AW-40-12 - 25 Kingsway - OBJECTION 18-3-2012

OBJECTION to AW/40/12 - 25 Kingsway - Alteration to front elevation

proposed roof plan

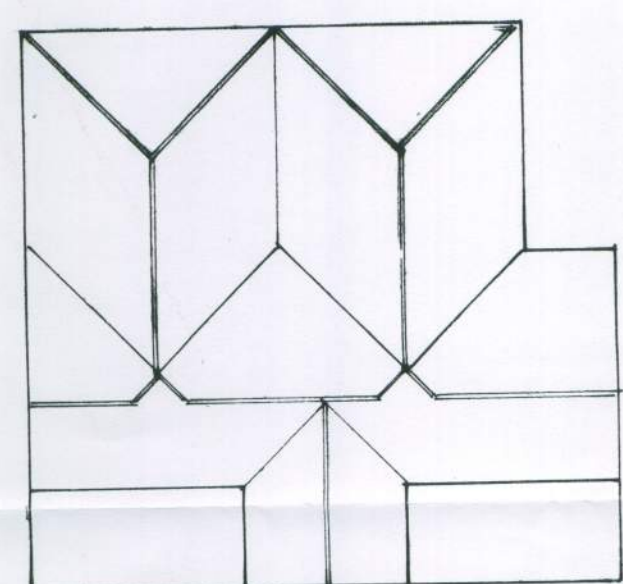
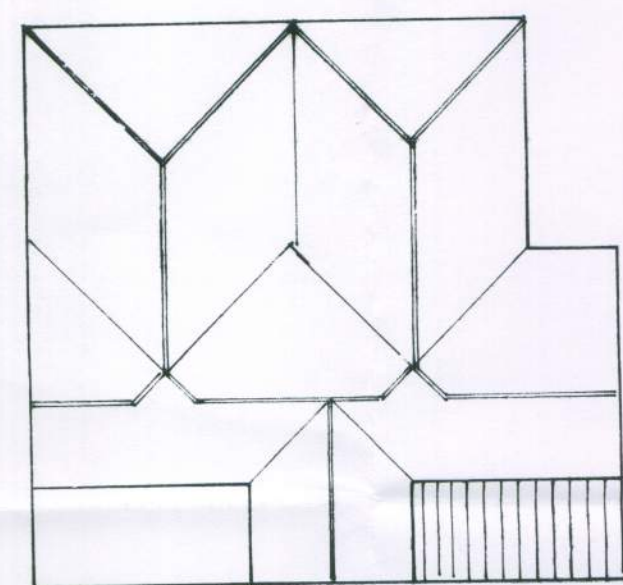
6. The applicant gives more detail regarding his proposed ‘external materials alterations’ (para. 3 on the Form) on the ‘Proposed External Alterations’ plan (2 of 2) than he does in the D&AS by annotating this ‘Remove existing concrete interlocking roof tiles and replace with Redland mini-Stonewolds’. CHECAA feels that the existing roof – with decades of life left in it and certainly not in need of replacement – is pleasing and that it blends well with the house and houses surrounding it.

7. We are not persuaded that stripping the existing roof and replacing it with grey Redland mini-Stonewolds would contribute anything towards preserving or enhancing the character of the CHCA or making a positive contribution to the environment.

sheet 2 of 2

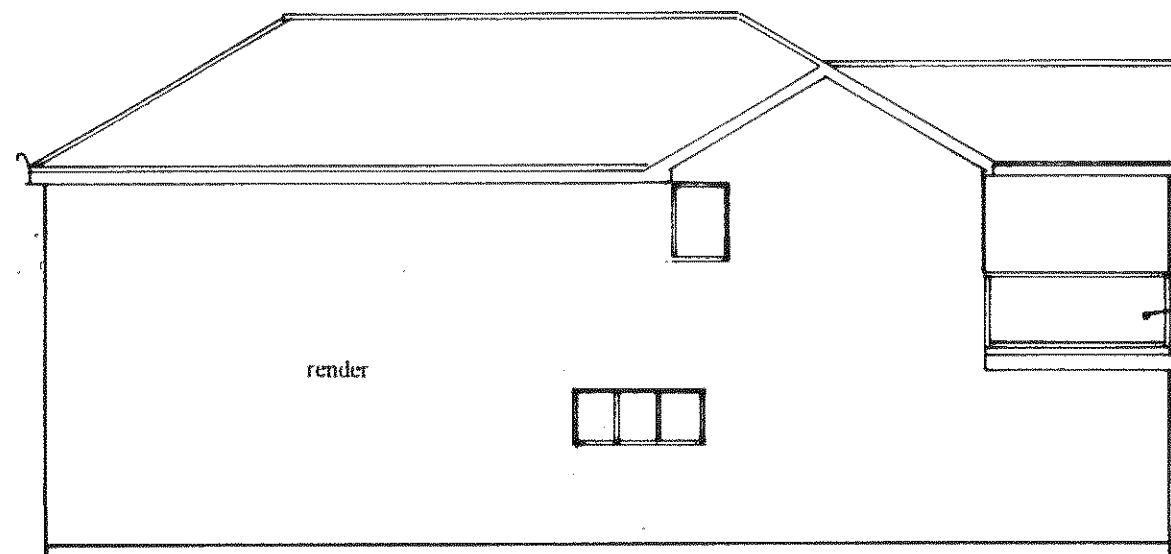
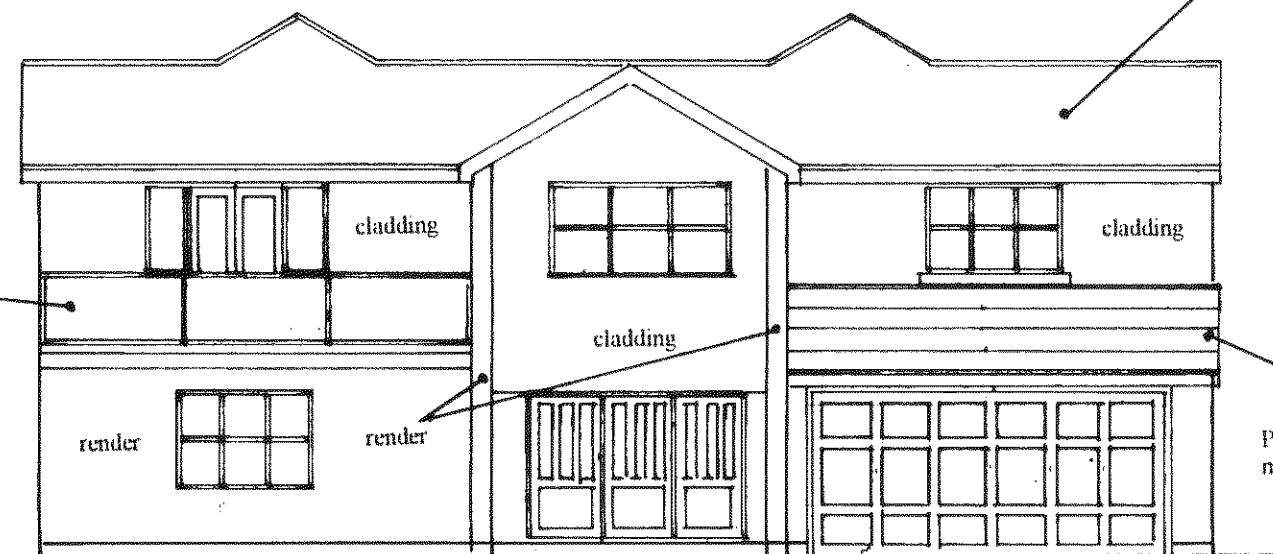
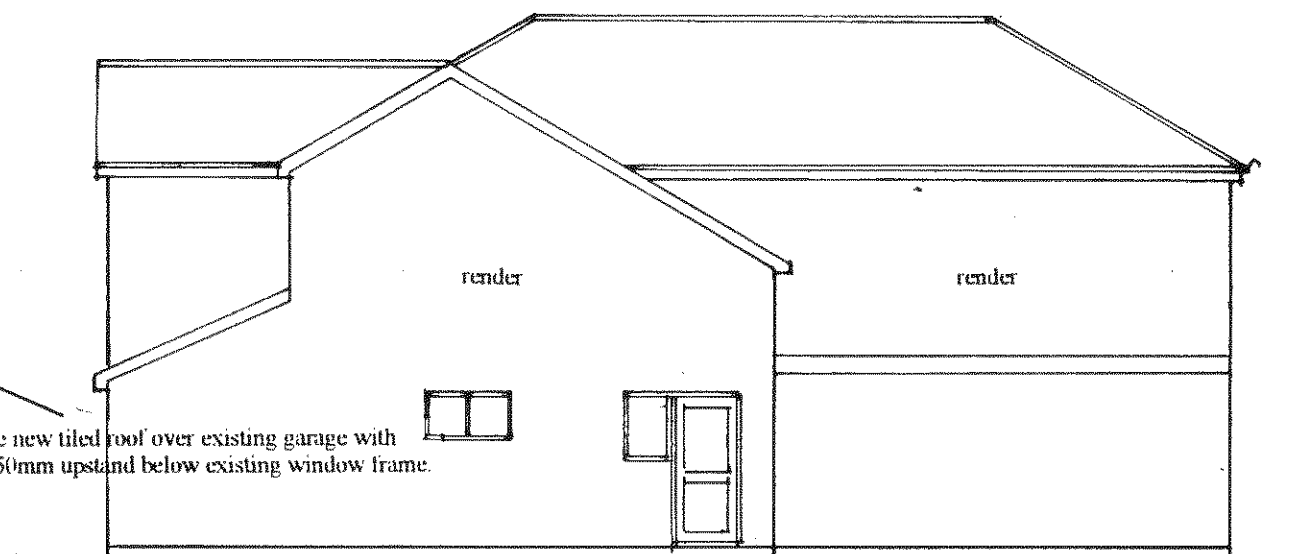
1. CHECAA regards the existing balcony rail of traditional Sussex wrought iron to be unobtrusive and pleasing in that the material is widely used within the CHCA and acknowledged in the Conservation Area Statement. To replace this with garish stainless steel and glass reflecting sunshine constantly in this east/west elevation would detract from the appearance of the building and fail to preserve or enhance the character of the house or the conservation area. It certainly would make no positive contribution but degrade the area, in our view.

2. CHECAA does not accept that the proposed lean-to tile covering of the garage is a 'catslide' roof, as is claimed, and the term is wrongly used, in our view. Such a low pitched tiled roof would destroy the existing symmetry (see photographs 'A', 'B' and 'C') in exactly the same way as would the applicant's proposals in AW/119/09 which was refused and objected to by CAAC who commented adversely upon those garage alterations which they said 'strong objection to the garage which subtracts from the symmetrical appearance of the property'. Current proposals would also do that and have an adverse impact upon the house and CHCA. Sir Edwin Lutyens was a pioneer of 'catslide' roofs and a photograph ('D') of one is attached for comparison. Counting the hung tiles from the garage roof to the window shows that the roof will rise from nil at the front (south) gutter by no more than 300mm at the window cill. The street scene will be merely 3-4 rows of grey tiles against the red wall hung tiles and we see no merit in that.

3. CHECAA cannot accept that the external cladding and colourwash rendering of the existing aesthetically pleasing, attractive and tasteful light brickwork will in any way serve to preserve or enhance the area. On the contrary, we consider that it will stick out like a sore thumb – not in a ‘wow’ factor way but a ‘yuk, what a mess that house is – what a blot on the landscape’ style - and that is not CHCA!
